Application number: 2025/92713	
What is the application for?:	Reserved matters application pursuant to outline permission 2023/92079 for erect
Address of the site or building:	Rear of, 23 to 43, Moor Lane, Gomersal, Cleckheaton, BD19 4LF
Postcode:	LS10 1NB

Type of comment: An objection	
Do you wish your comments to be published on the website anonymously?	Yes
Reserved matters application pursuant to outline permission Application number 2025/61/92713/E	
Underground Water Attenuation System	
<p>Since original developer Binks Executive Homes Ltd sold the site to a new developer, PPJ Developments, they have made wholesale changes in the submitted layout and design, including significant alterations to the drainage scheme.</p> <p>In the original proposals was a concrete water attenuation Pipe sunk into the ground, 45metres x long and 1.8 metres diameter. This was to help control the flow of surface water during heavy rain.</p> <p>The latest plans from PPJ Developments show two underground attenuation installations, one 18.0 metres x 5.0 metres x 2.0 metres deep and another 24.0 metres x 4.5metres x 0.8 metres deep. One is to be positioned under the Refuse vehicle turning space and one

Polystorm Attenuation Tank 2
Plan View
 (Scale 1:25)

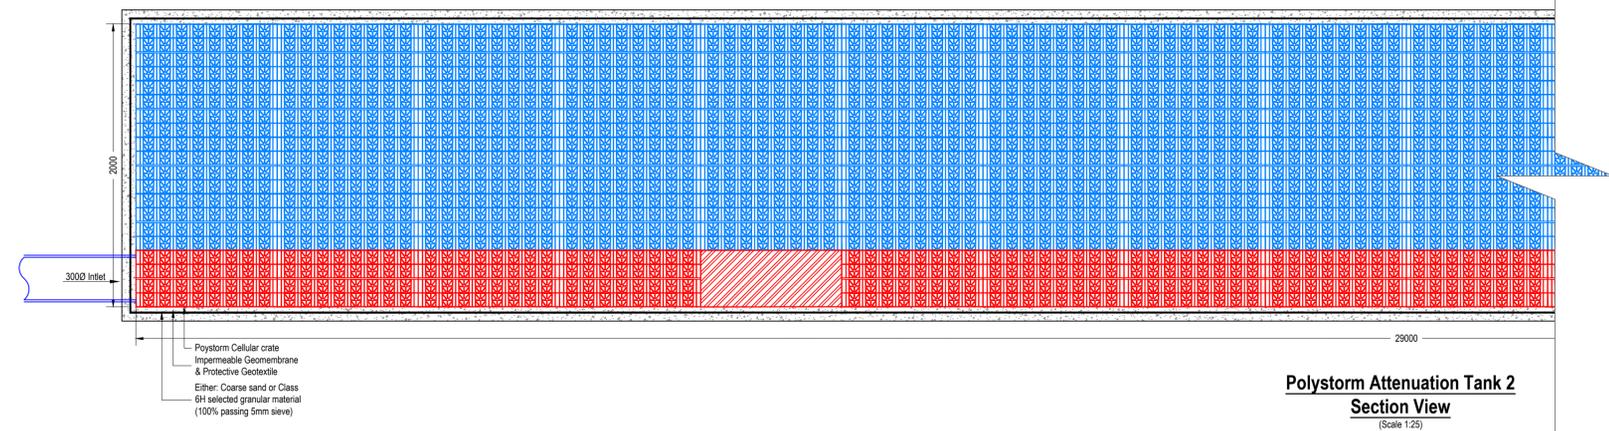
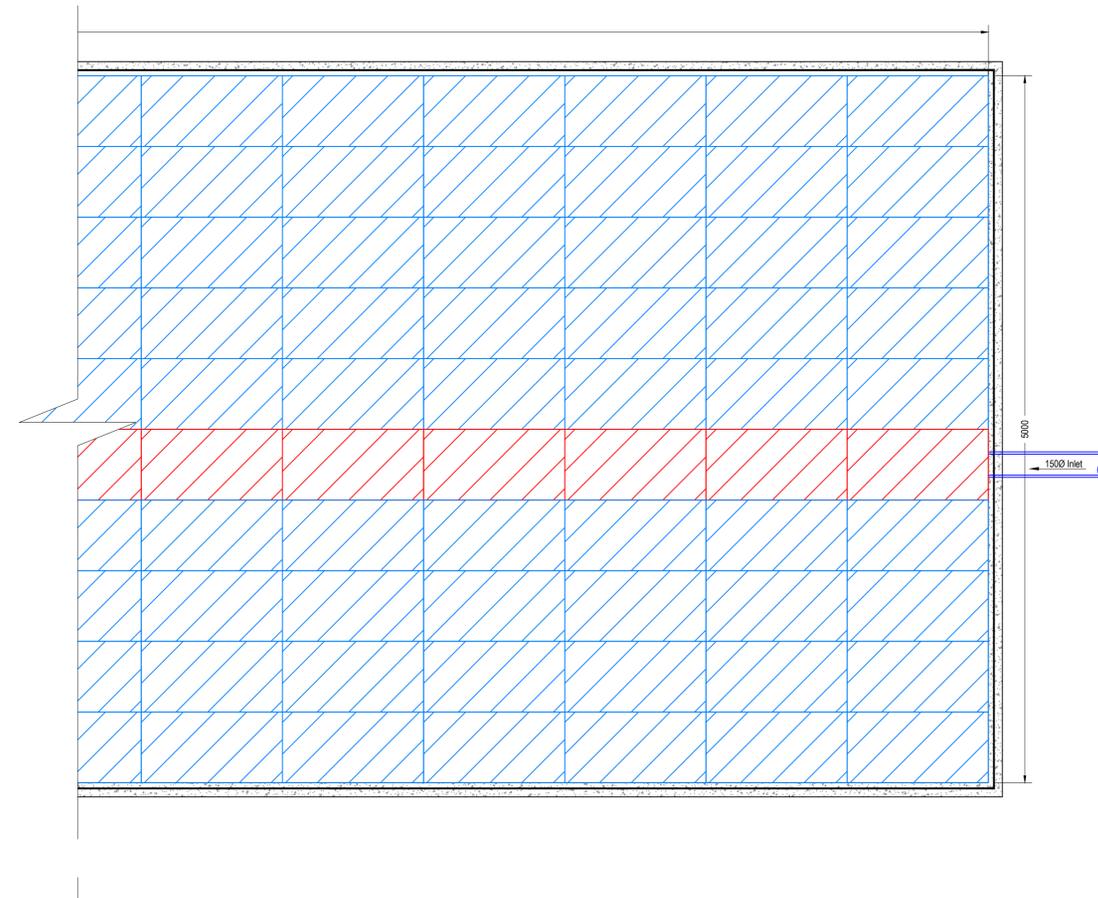
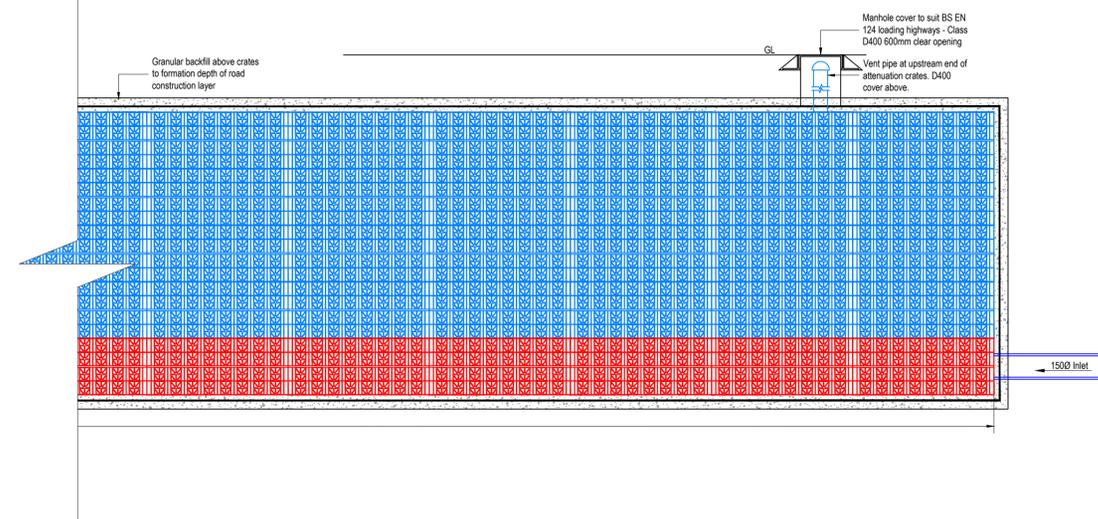
On checking one manufacturers web site, it suggests and quote Such Systems must be located at least 5 metres away from buildings and roads and 2.5 metres from boundaries to avoid structural issues.

As the various site surveys show, the land has stability issues due to past mining, to the extent that some houses will have to be built on raft foundations to overcome any settlement issues.

As such there could also be a risk of settlement to these two reservoirs and if excessive, the liner could split allowing water to seep out into the surrounding ground, and subsequently flood the properties to the South and East of the development.

As the proposed installation can only be inspected and maintained from the surface via inspection chambers and rodding eyes, any remedial work would be difficult and if any serious issues materialise this could possibly result in the driveways having to be dug up.
